Proposed new Bank Building (Southwest Capital Bank)
Located at the SE Corner of Central Avenue and 15th Street
1410 Central Ave (a.k.a. 120 15th Street) Albuquerque NM 87104

Project # 1009118, Case # 12 EPC 400002

RMKM submitted a site development plan for building permit to the City of Albuquerque's Environmental Planning Commission. The project was approved with conditions on April 12th, 2012. This letter serves to list all changes which have been made to the EPC approved drawings.

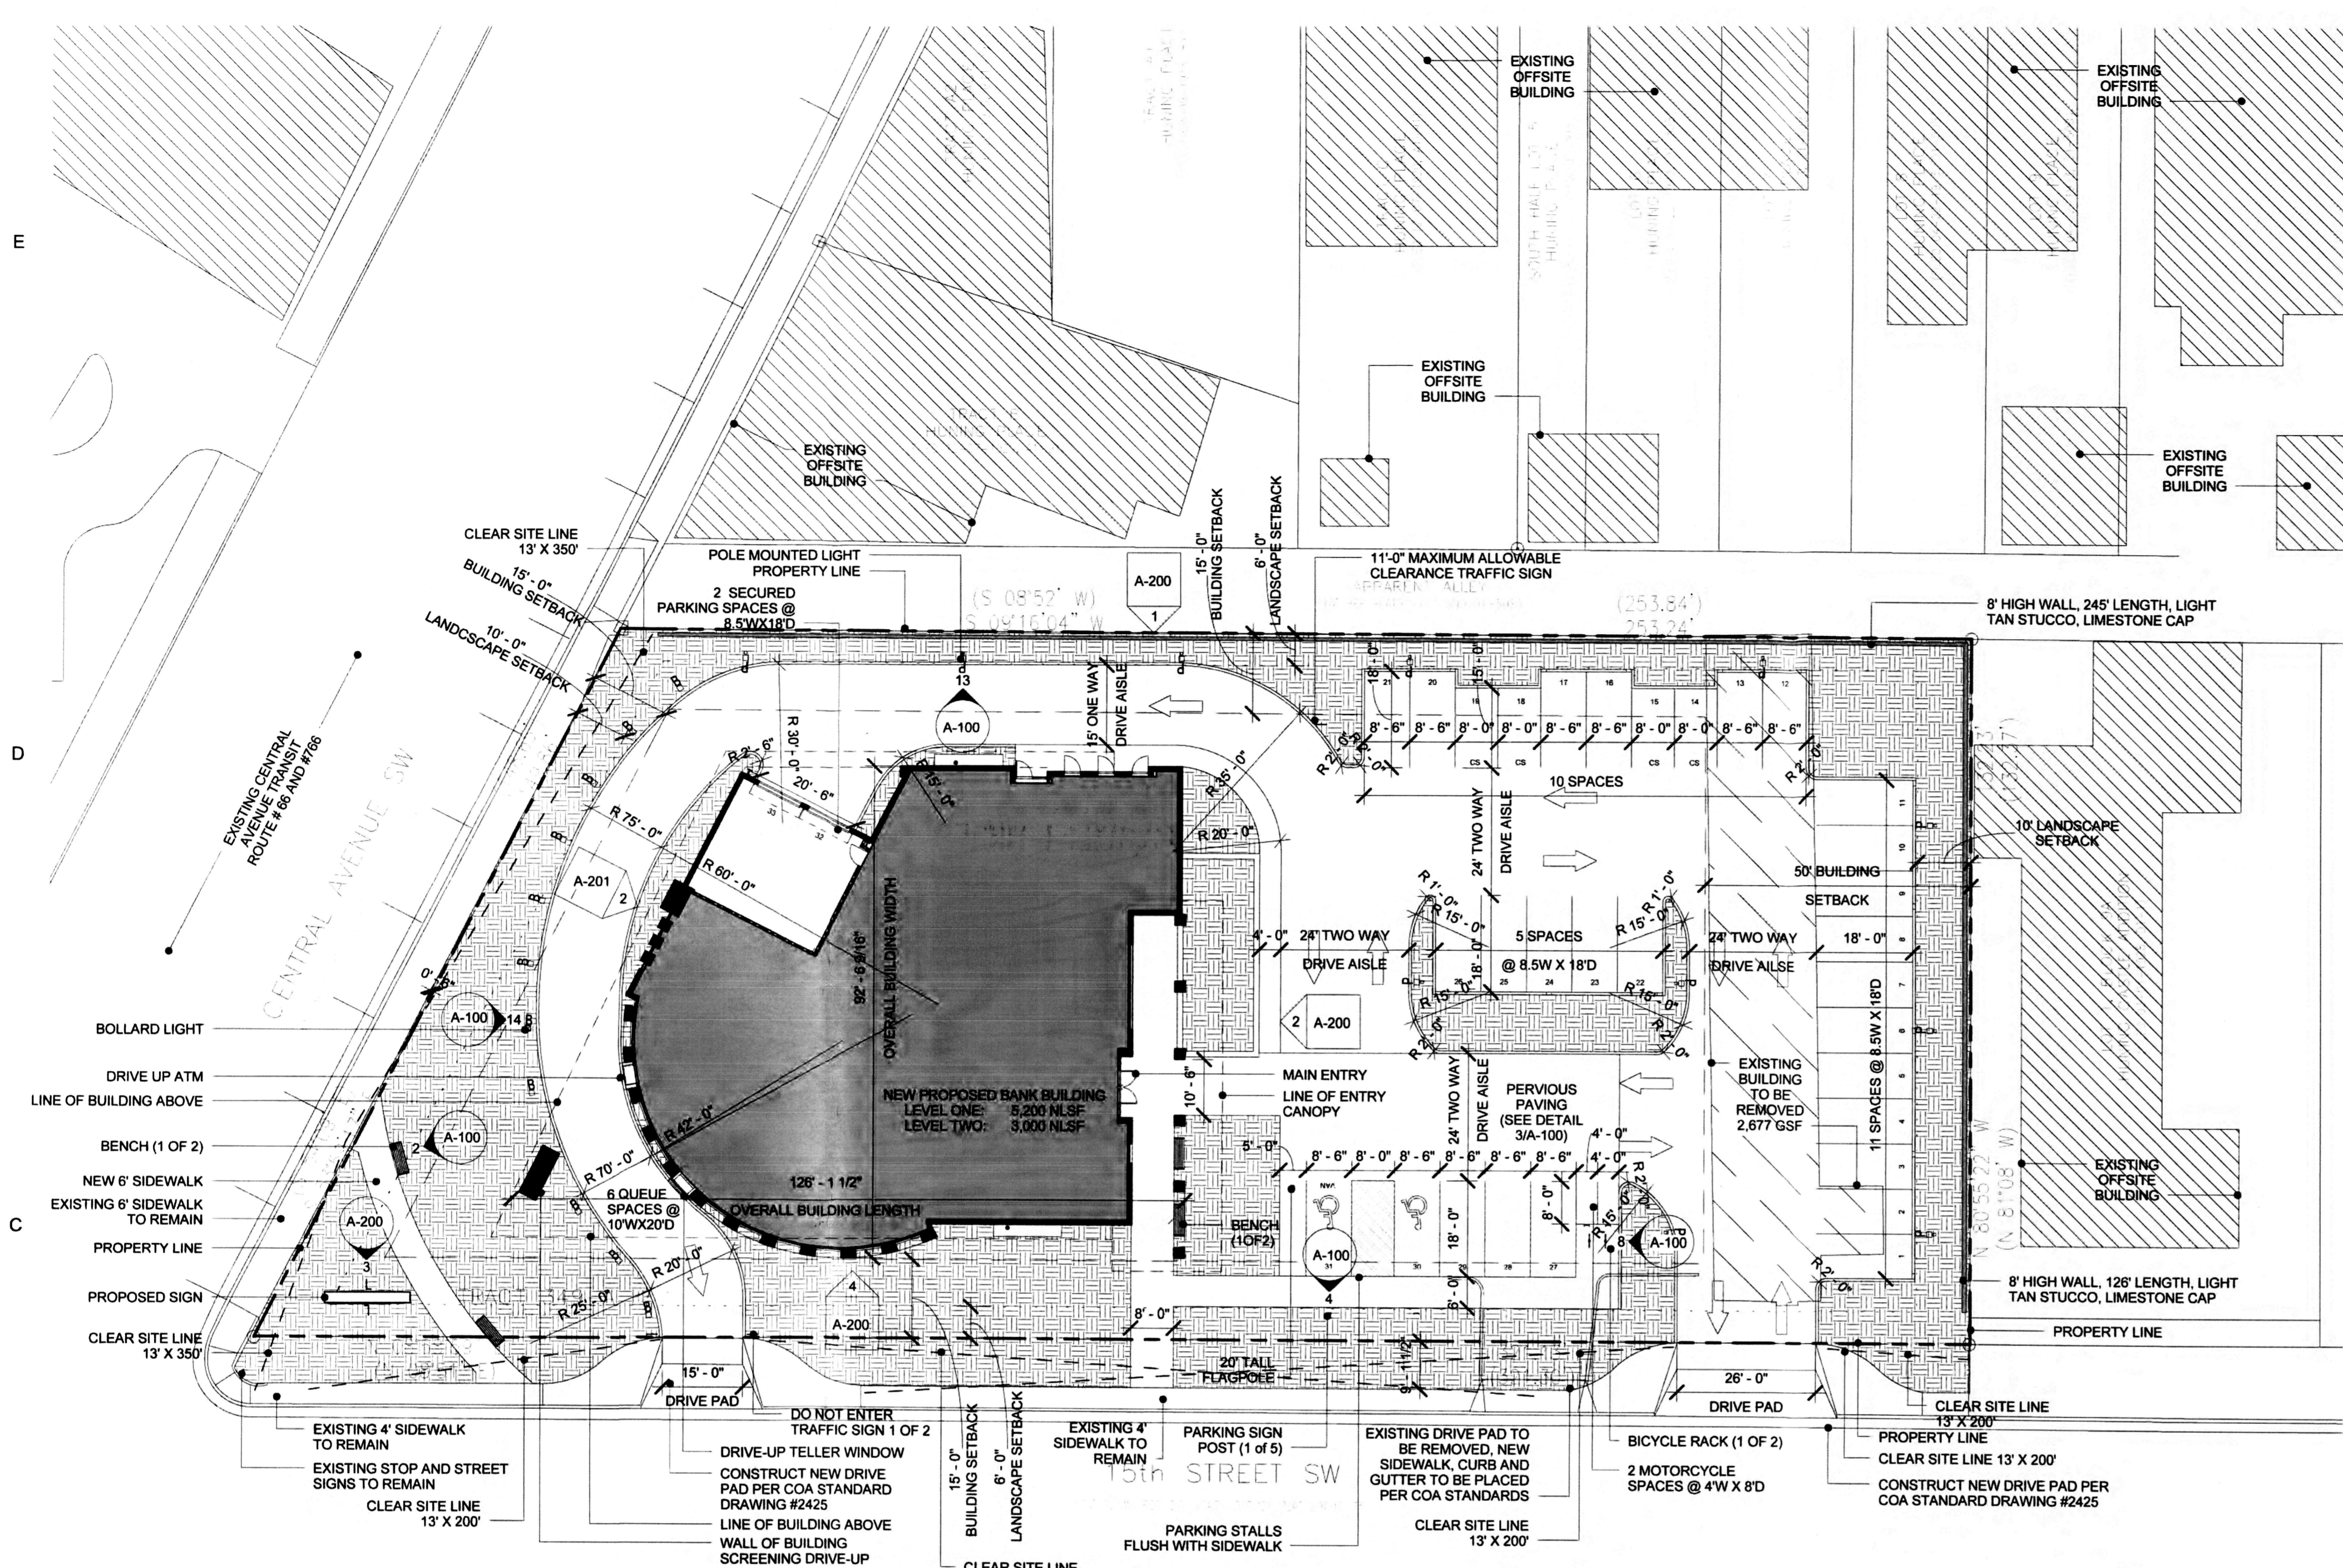
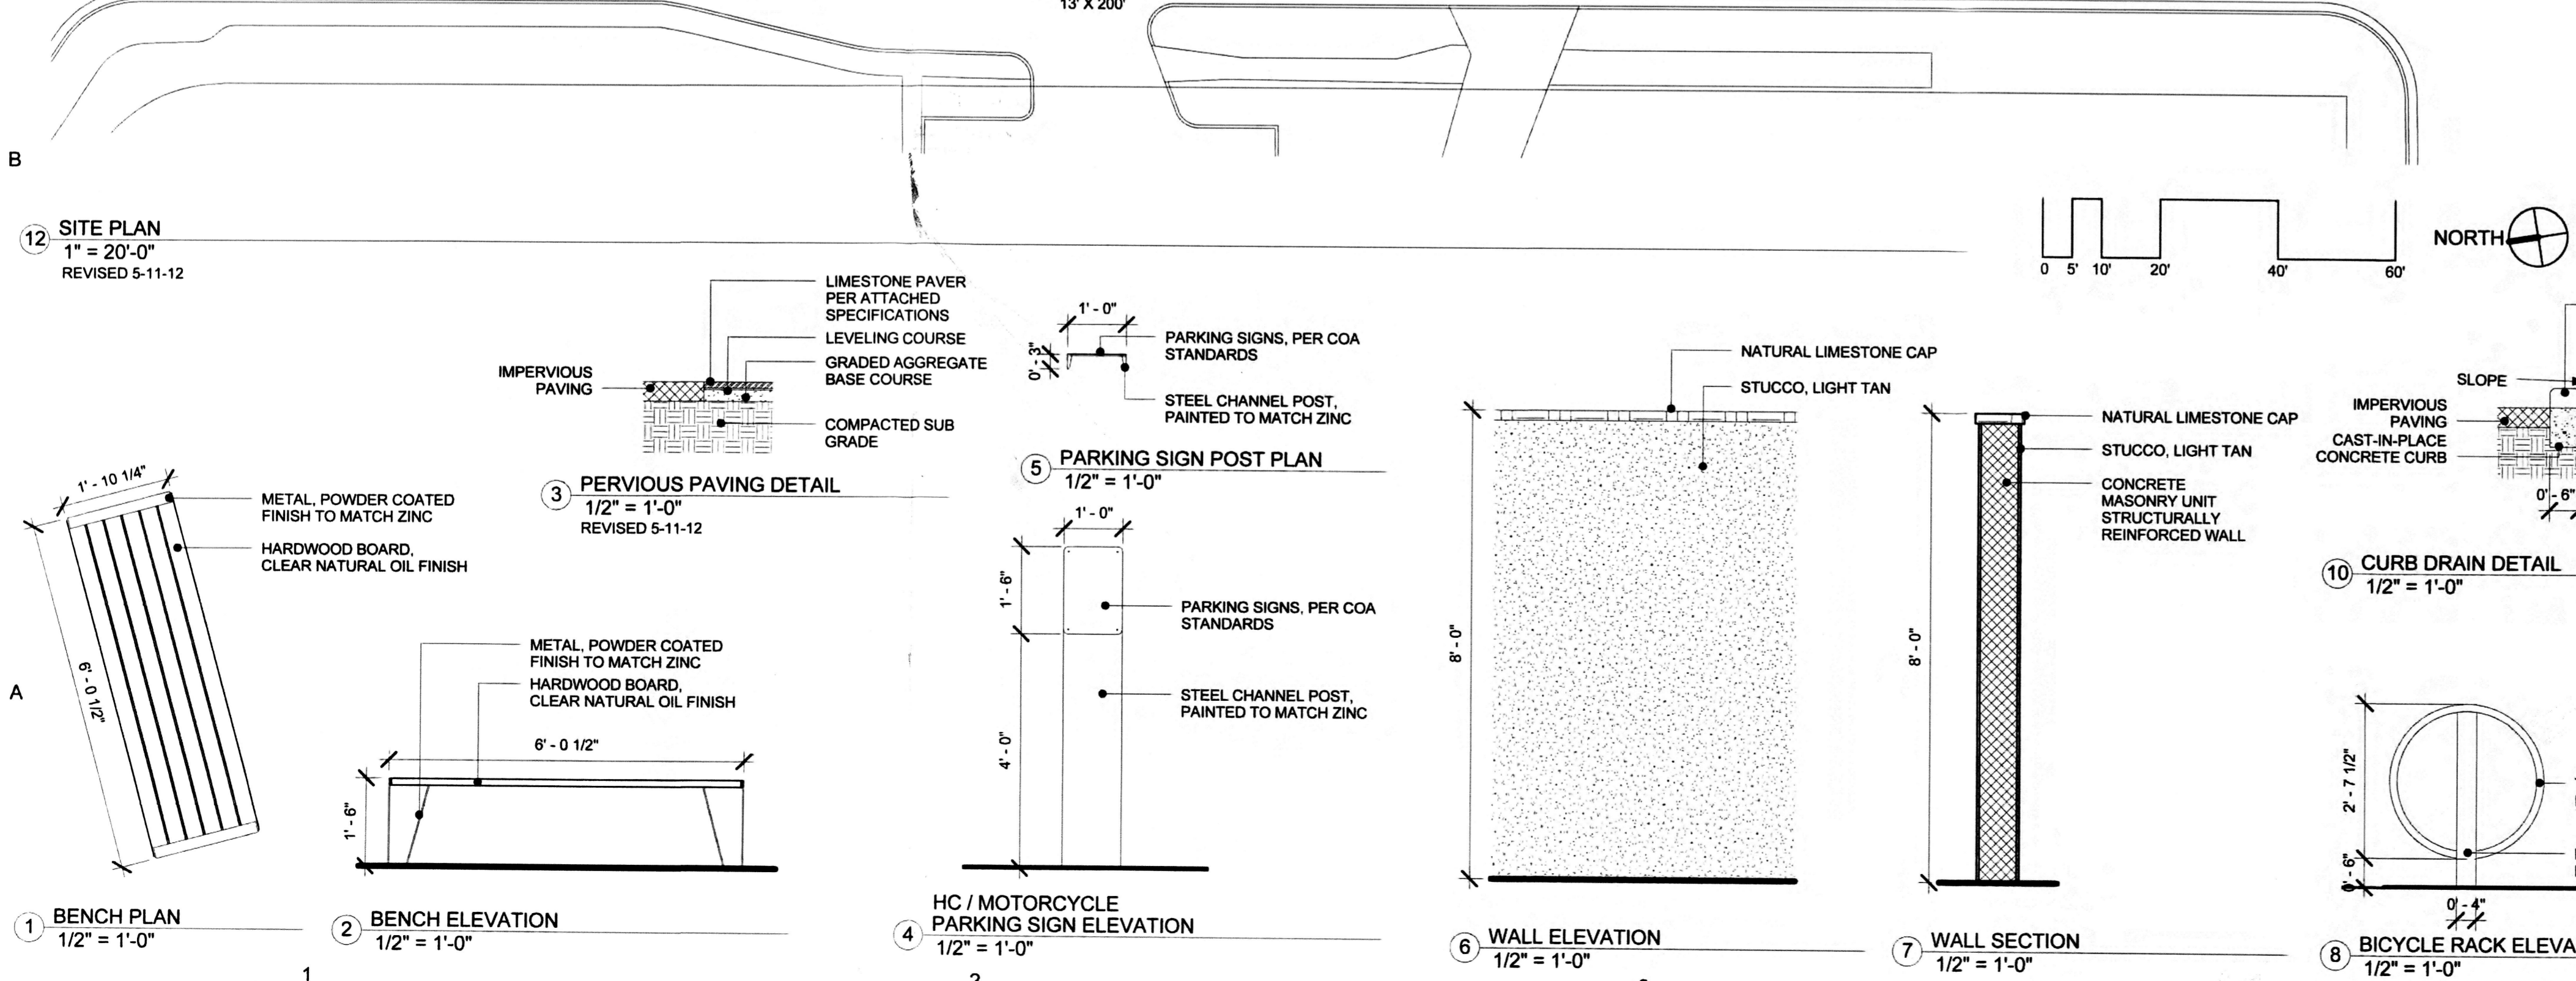
- 3. The applicant shall provide outdoor space for the public at the primary entrance (south side) of the building (Section 14-16-3-18)(C)(3)). Two benches have been included at the building's SW corner adjacent to the main southern entry.

- a. Provide a sight distance exhibit at the existing curb cut along Central. The proposed wall may need to be lowered in this area. A 35' clear site triangle is indicated with revised plantings of a maximum 30" height.

- b. Pavement markings and signage must be provided for the drive through exit. One way pavement markings are indicated and do not enter traffic signs are indicated at the drive through exit.
